**Subject:** City of Charlotte – Urban Forestry Rezoning Petition Review Summary

**Review Date:** July 29, 2021

**Rezoning Petition # OR Pre-submittal meeting:** 2021-085

Date	Description/Status
7/29/2021	UF 1 <sup>st</sup> review

**SITE PLAN**

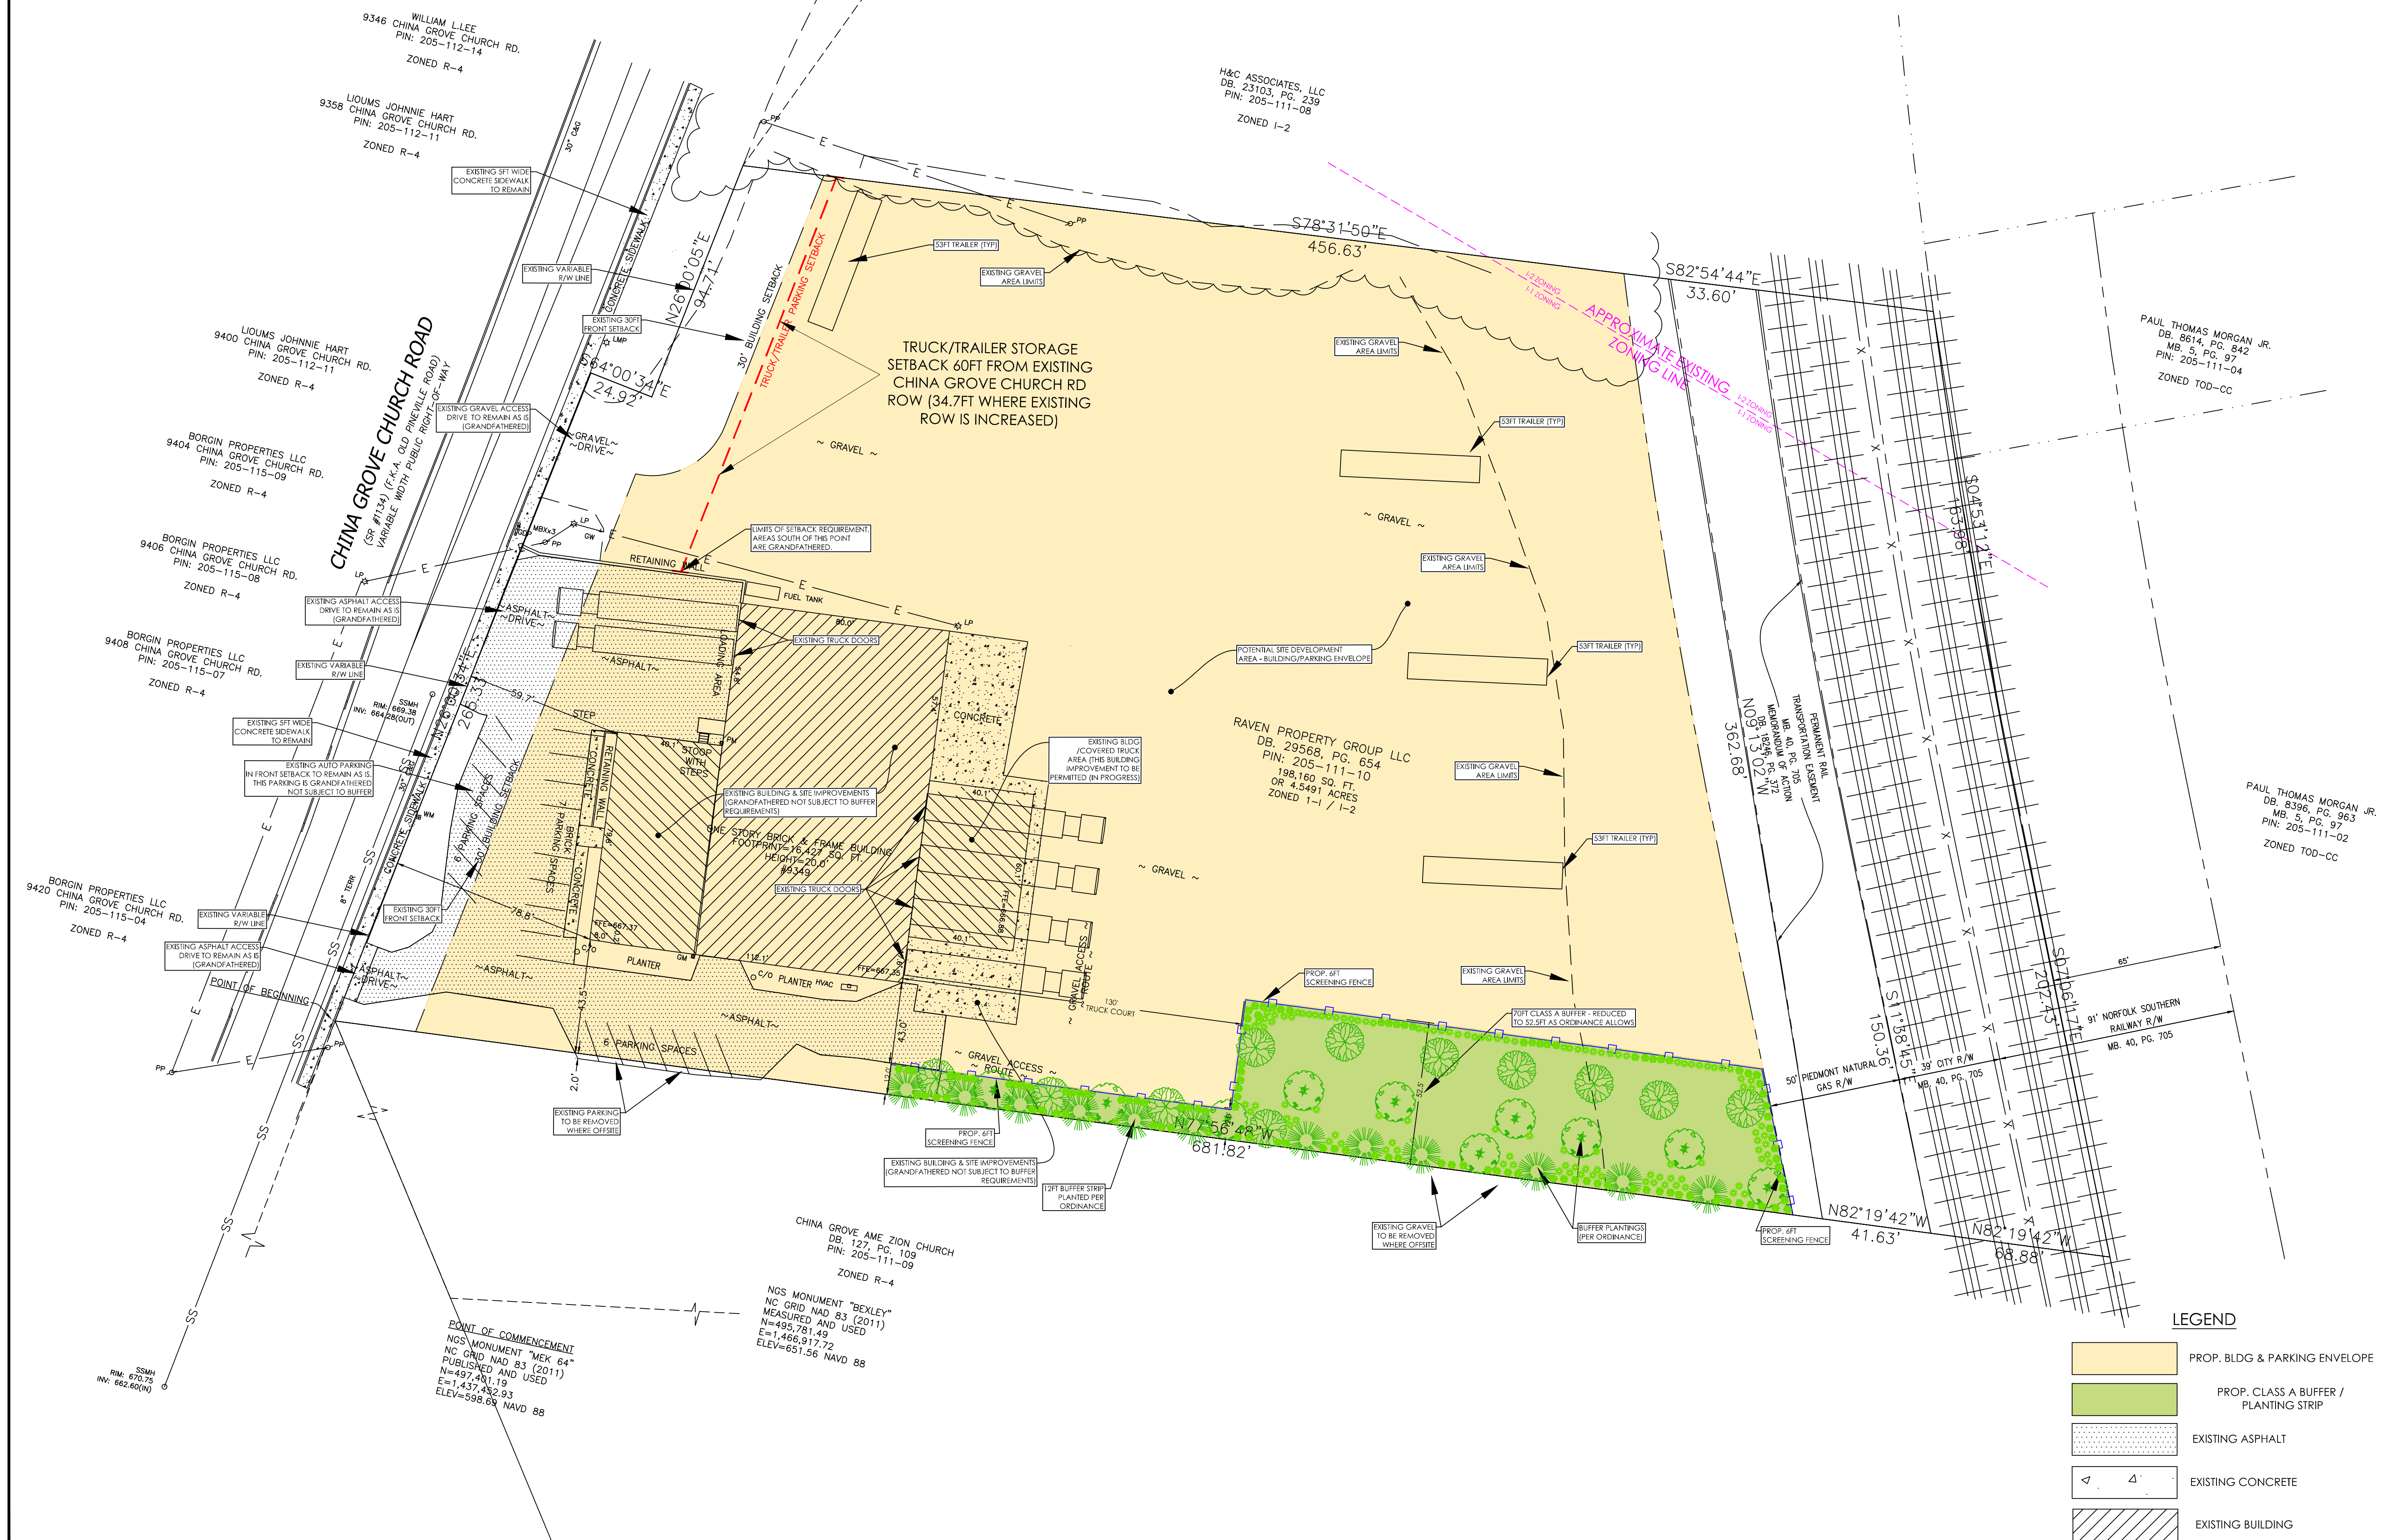
- A tree survey shall be submitted identifying all trees of eight-inch (8) dbh or greater and all planted trees of (2) two-inch caliper or greater and six feet in height that grow partially or wholly within public street right-of-way. The survey shall also identify all trees of eight-inch dbh or greater within the tree protection zone. Tree protection zone mean a distance equal to the designated zoning district setback or 40 feet from the front property line, whichever is less, or from the side lot line on a corner lot.

- All existing City street trees in public street right-of-way (City or State-maintained) are required to be preserved per the Charlotte Tree Ordinance and the following Tree Ordinance Guidelines: 1) City Trees & Protected Vegetation; 2) City Tree Mitigation Policy.

- Perimeter Trees: Street trees are required to be planted along all public roads per the Charlotte Tree Ordinance
  - o Small-mature tree species are required in locations where overhead distribution lines may impact natural tree growth.
- Internal Trees: Internal trees may be required to be planted in all surface parking lots and to mitigate impacts from impervious surfaces on-site.

- Site is in violation of Charlotte Tree Ordinance must depict how site will come into compliance with all applicable perimeter tree, internal tree/parking lot tree planting, and tree protection zone requirements.
